From: Stuart Corbey
Sent: 09 October 2018 17:00
To: Karen Parsons
Subject: FW: EP/120/18/PL - The Loft 131A Sea Road - Change of use of boat store & sail loft (Sui Generis) to 1 No. dwelling (C3 Dwelling house).

Subject: EP/120/18/PL - The Loft 131A Sea Road - Change of use of boat store & sail loft (Sui Generis) to 1 No. dwelling (C3 Dwelling house).

131 Sea Road, East Preston, Littlehampton, BN16 1PD

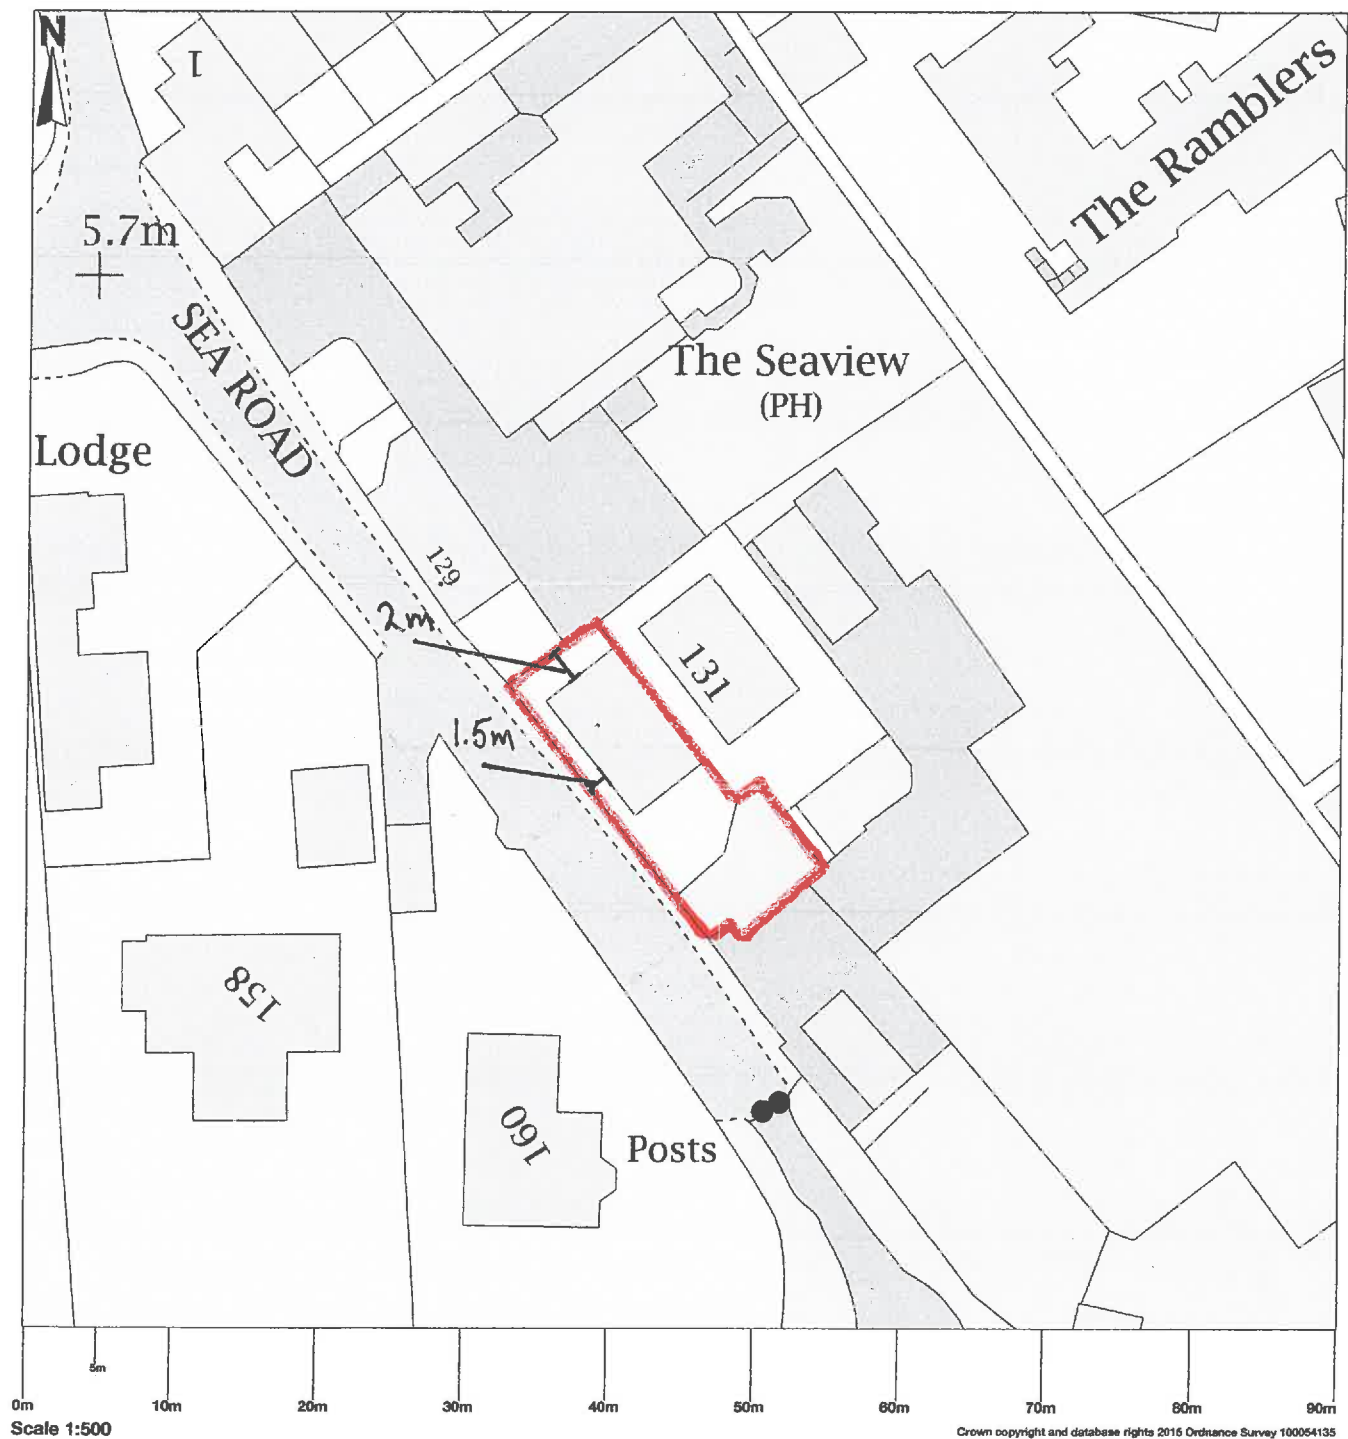
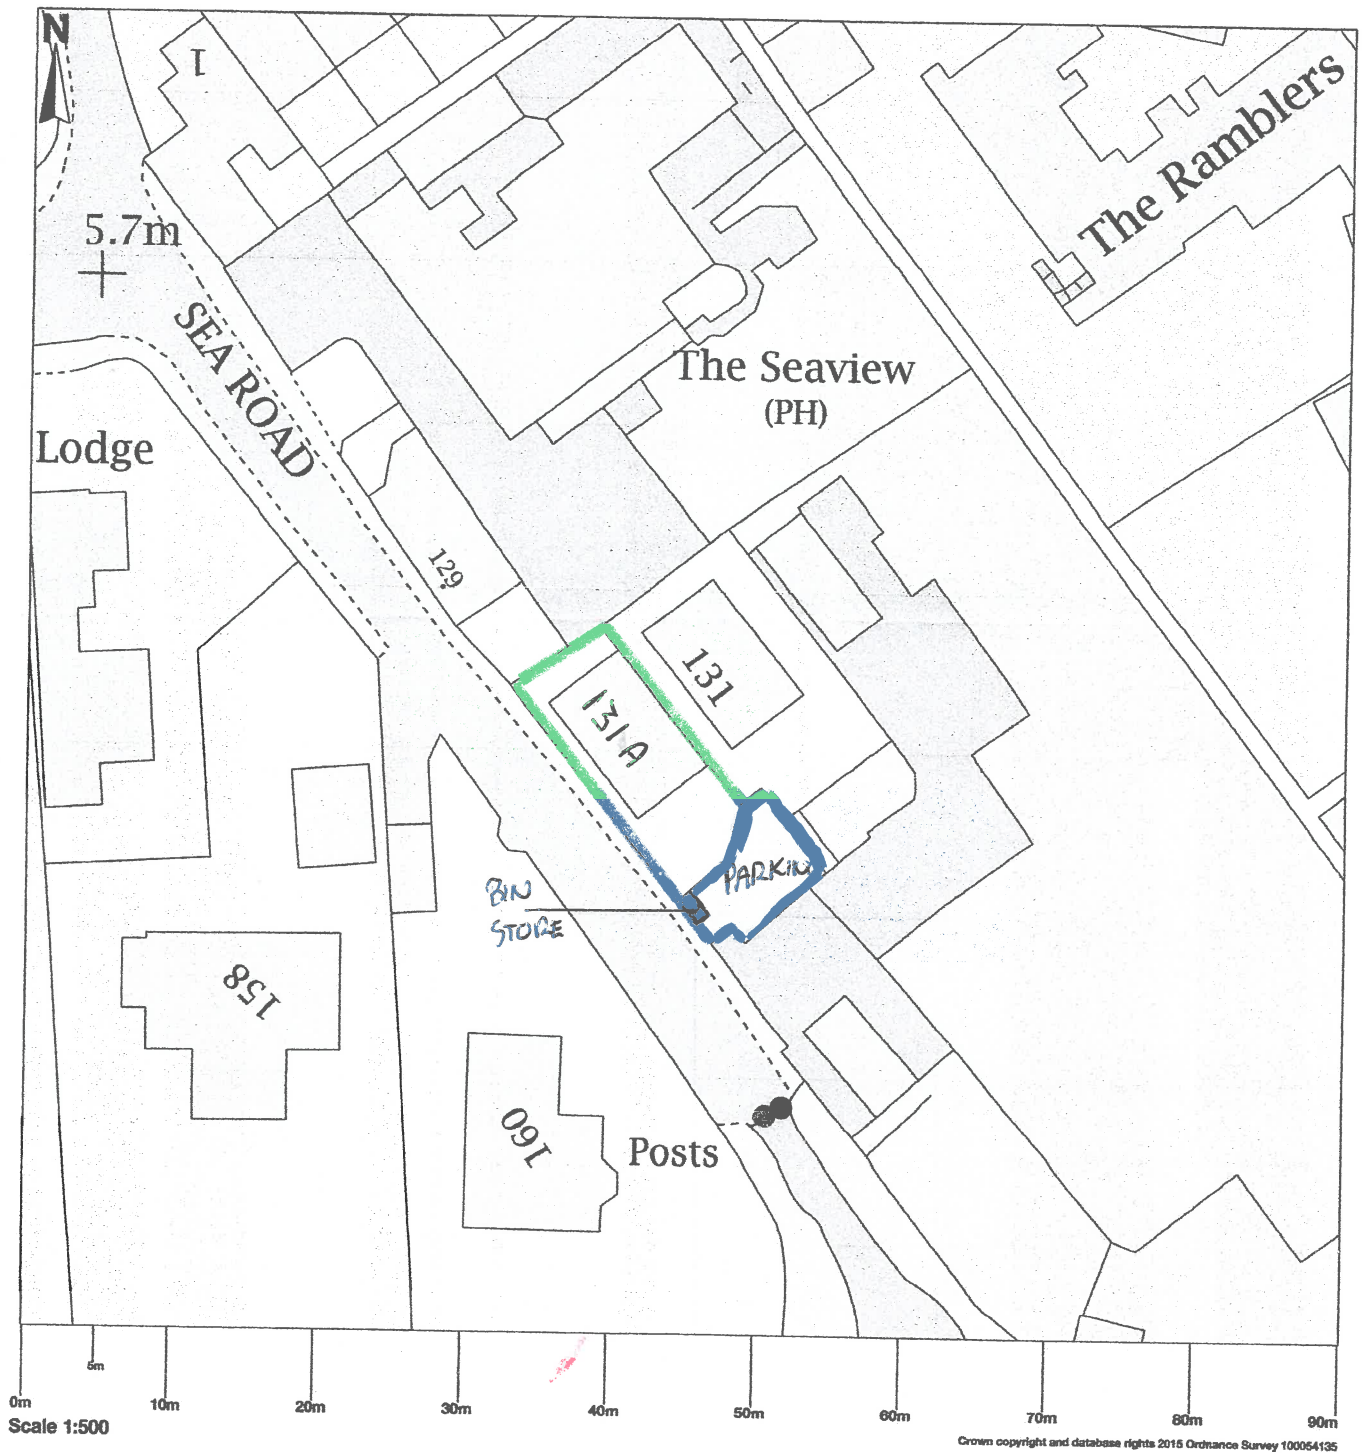
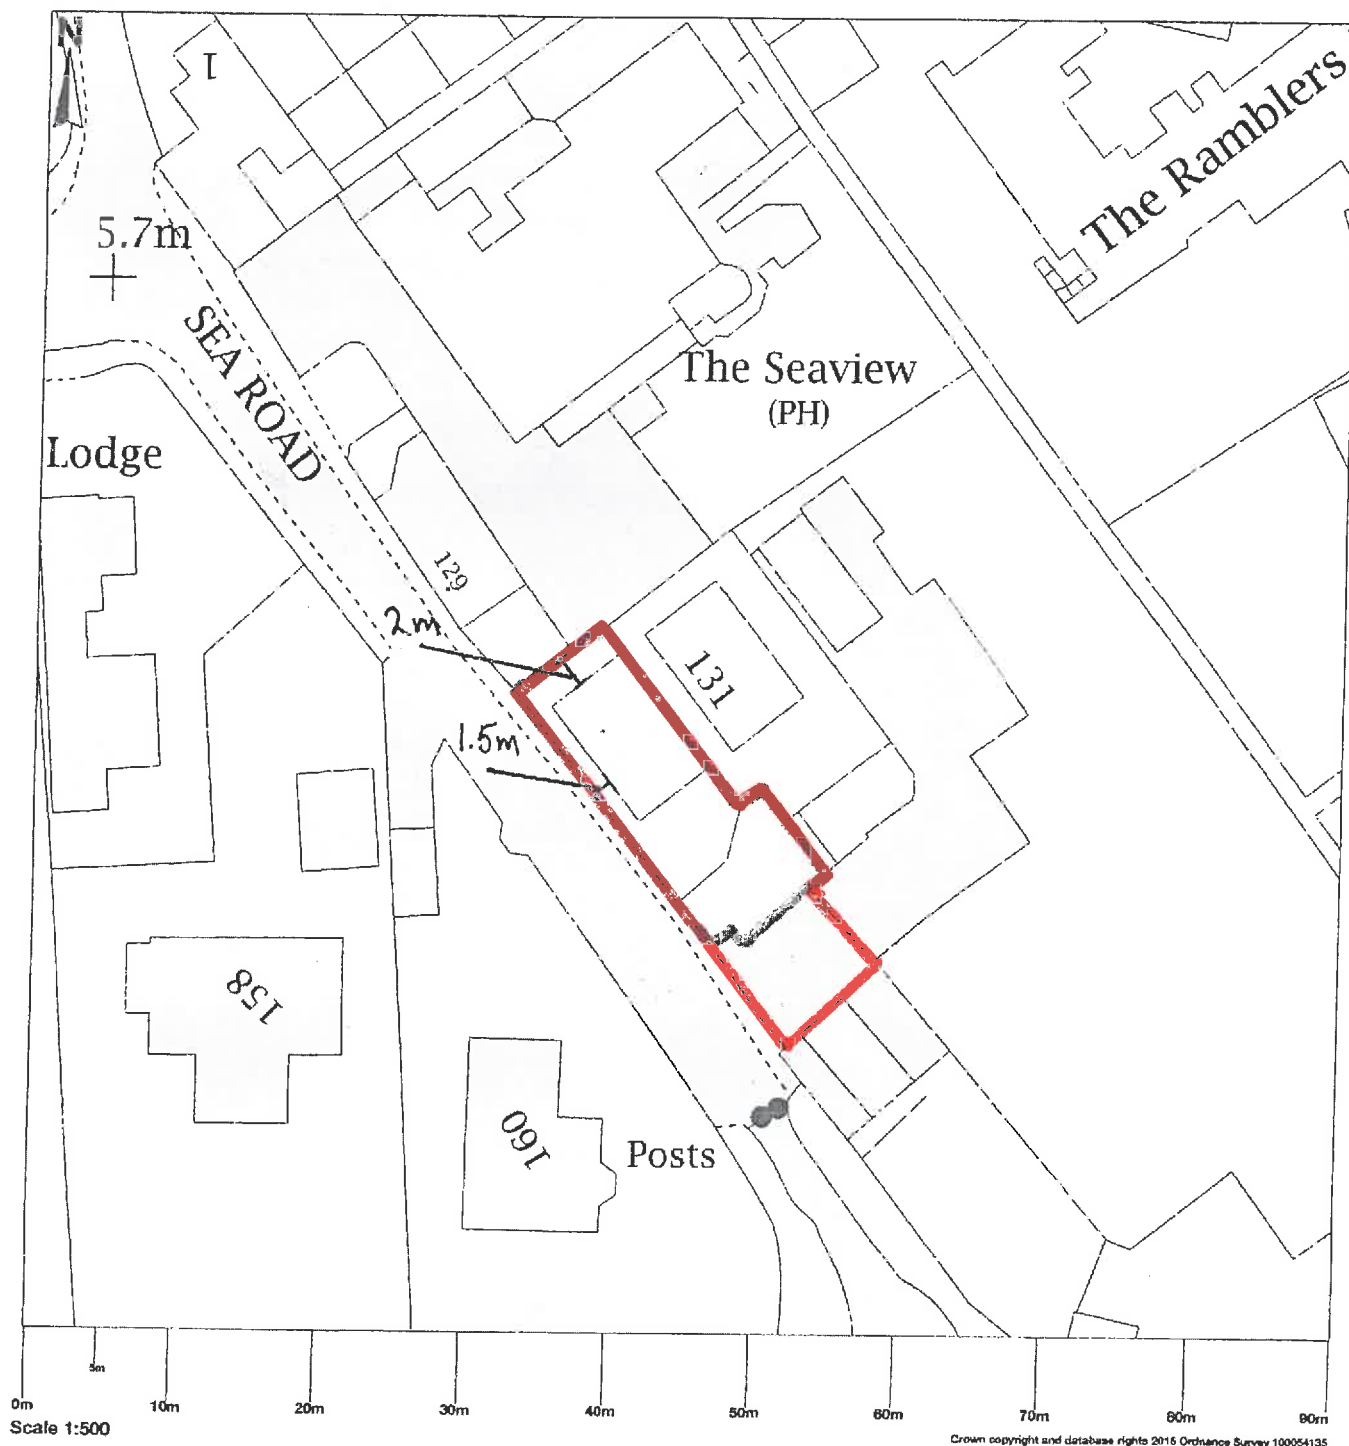
In regard to the parking arrangement. From conducting a site visit it would appear the access to the parking space is via a gate which could be outside the occupants control. Could you confirm the position as the red line should include a means of access to the public highway, and a certificate B seeking permission from land owners of the access (if not in the ownership of applicant) should be sort.

EXISTING + PROPOSED
FIRST FLOOR PLAN

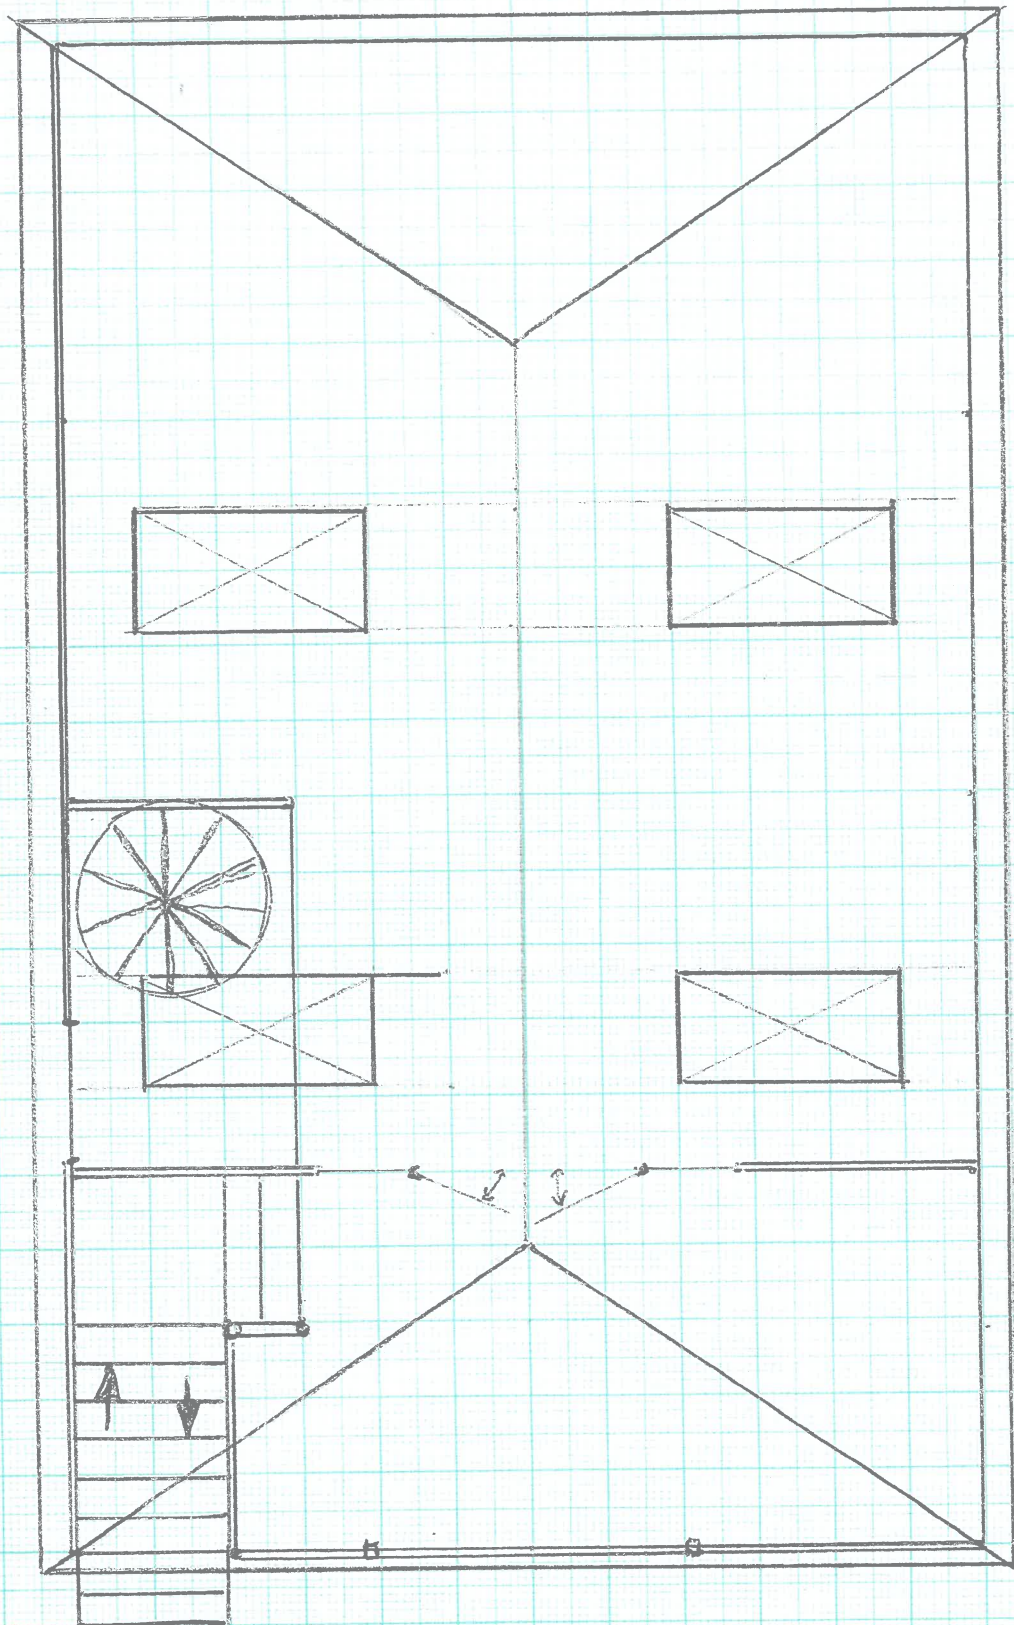
Would you be able to provide a clear ground and first floor layout plan with the rooms listed to assist with our assessment.

As for the floor plans, the client is updating these and I will forward as soon as received.
